APPLICATION BY ONE EARTH SOLAR FARM LIMITED

POST HEARING SUBMISSIONS ON BEHALF OF LINCOLNSHIRE COUNTY COUNCIL [ISSUE SPECIFIC HEARING TWO]

Figure 11.1: Site Location and Study Area

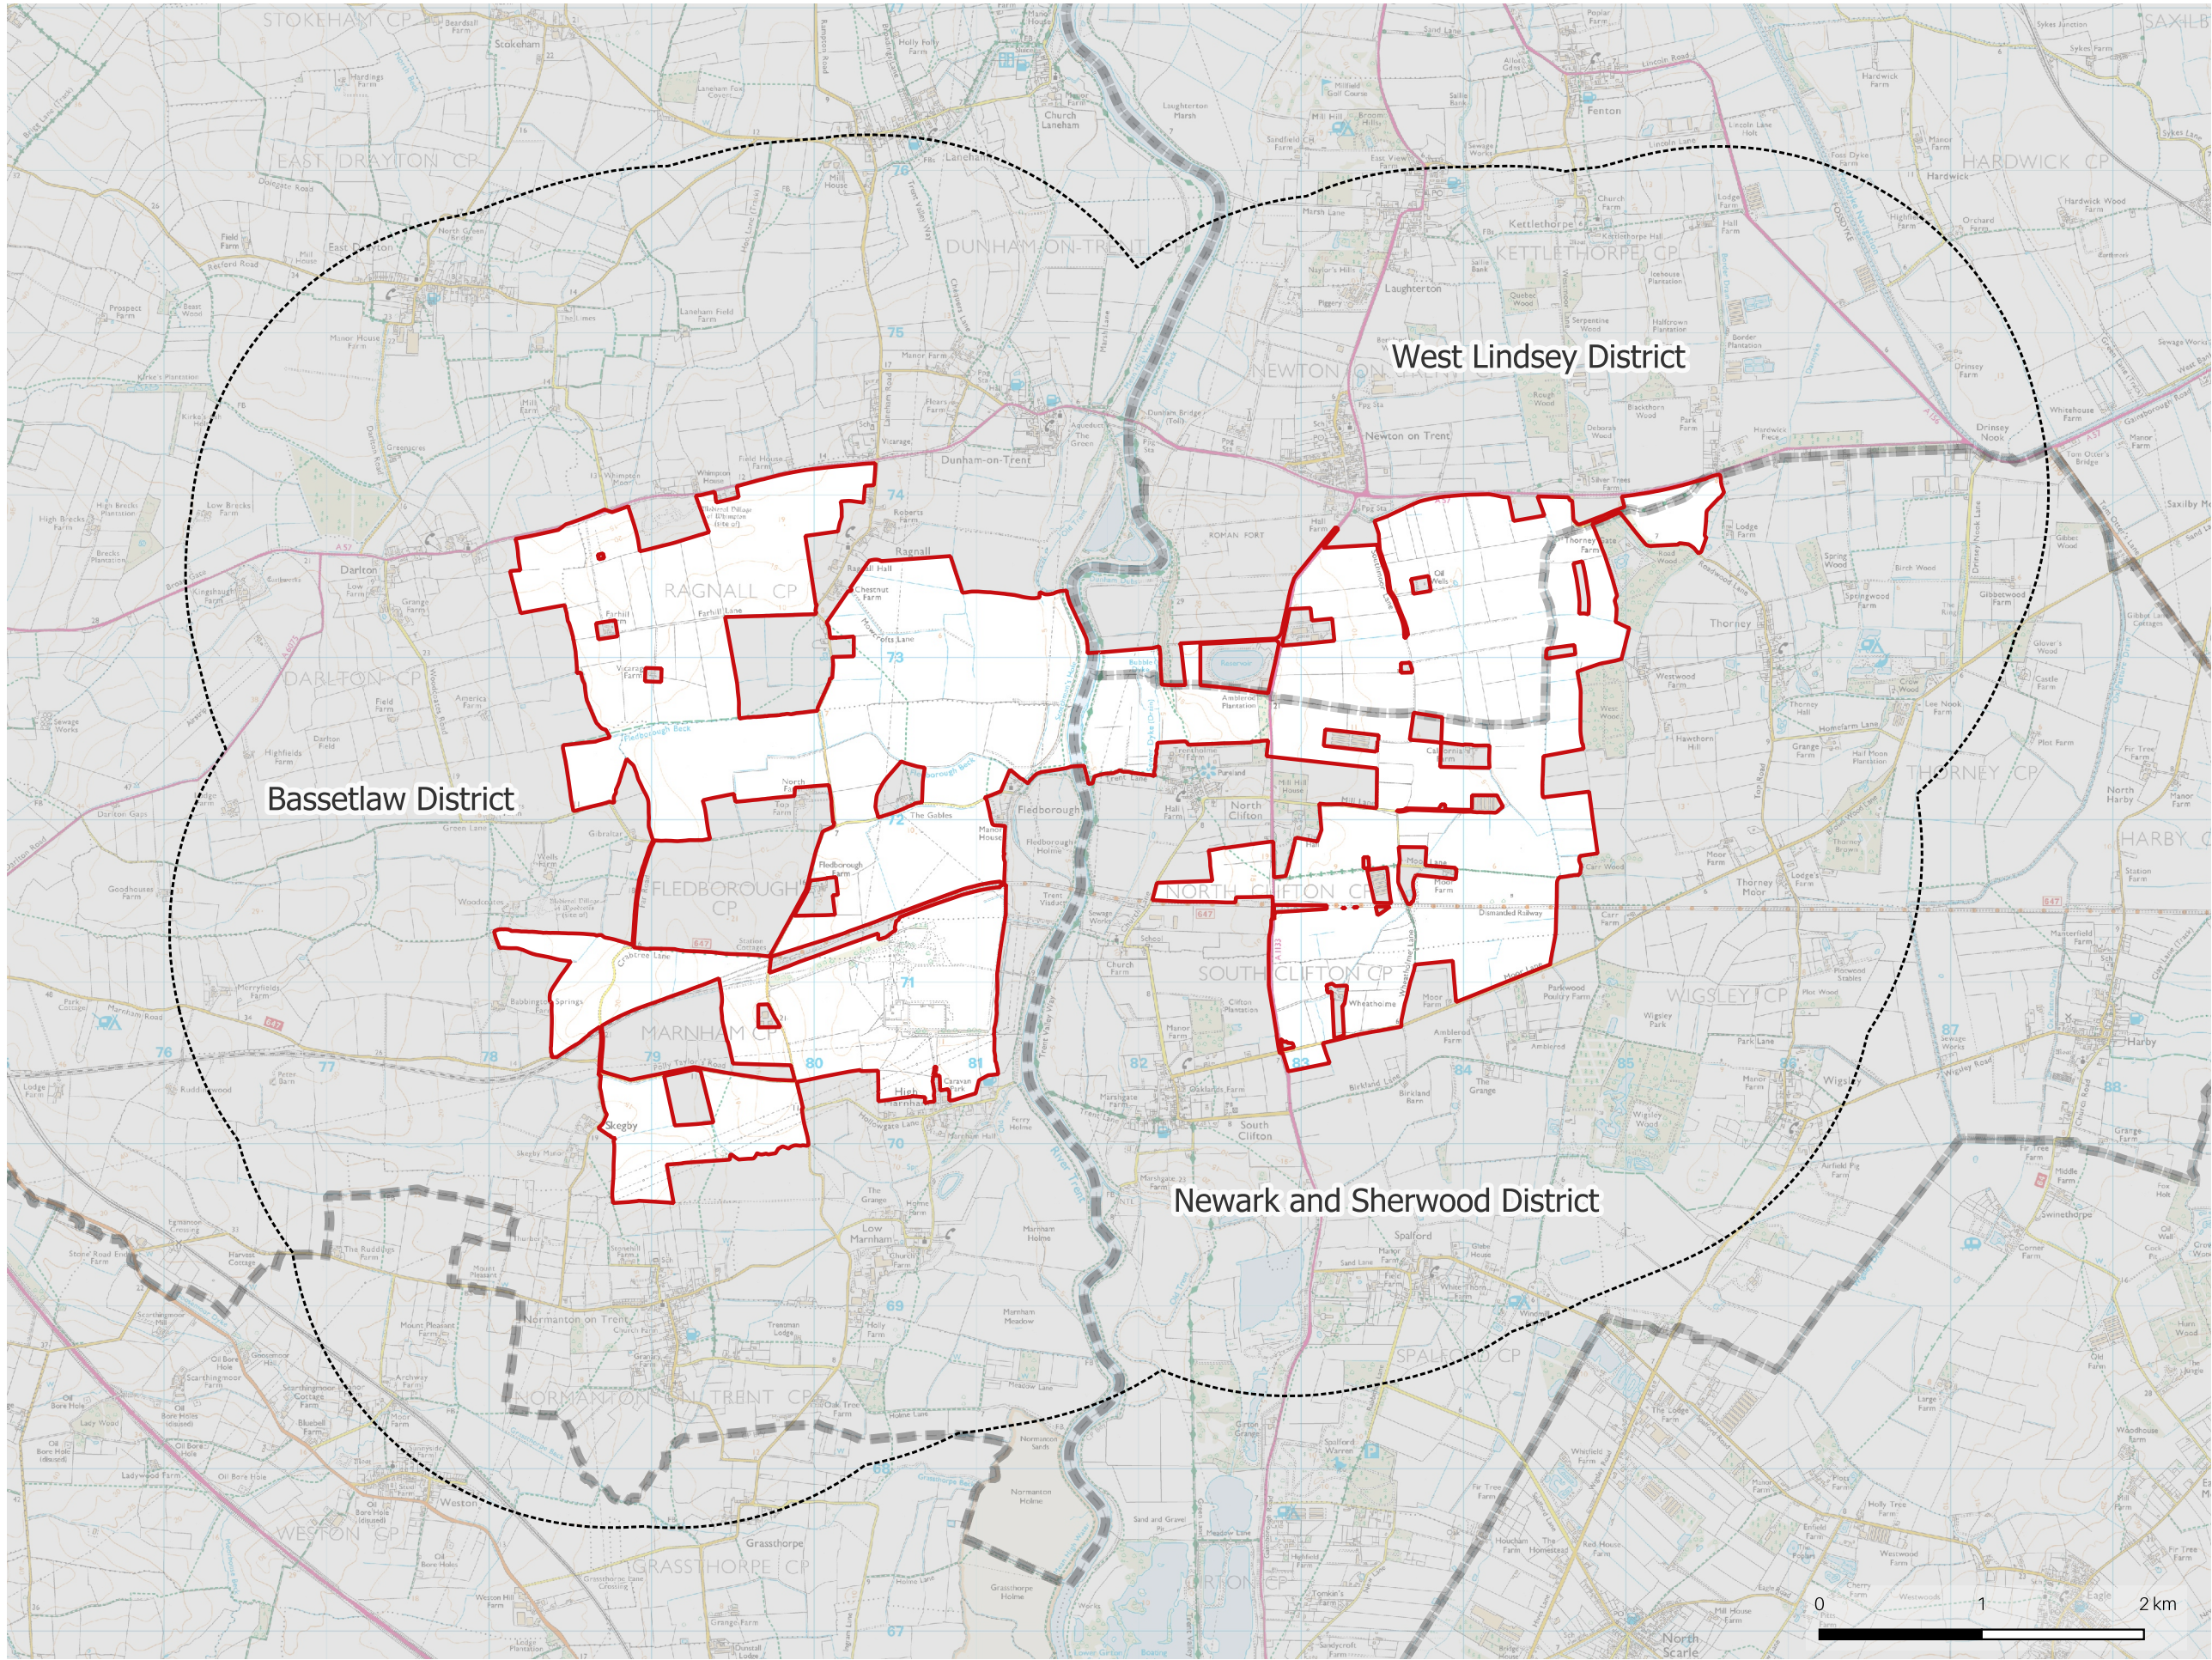
2. The five discrete issues under item 4 are now addressed in turn.
3. **Agenda Item 4 (i)** seeks views on the suitability of a 2km search area and a broader understanding of the effect on landscape character areas. LCC have not identified anything on Site or within the wider landscape to contradict the Applicant’s position that there would not be Significant effects of the One Earth scheme in isolation beyond 2km. Typically distance reduces the likelihood of Significant effects occurring. Therefore, we agree that a 2km study area for the One Earth scheme in isolation is appropriate.
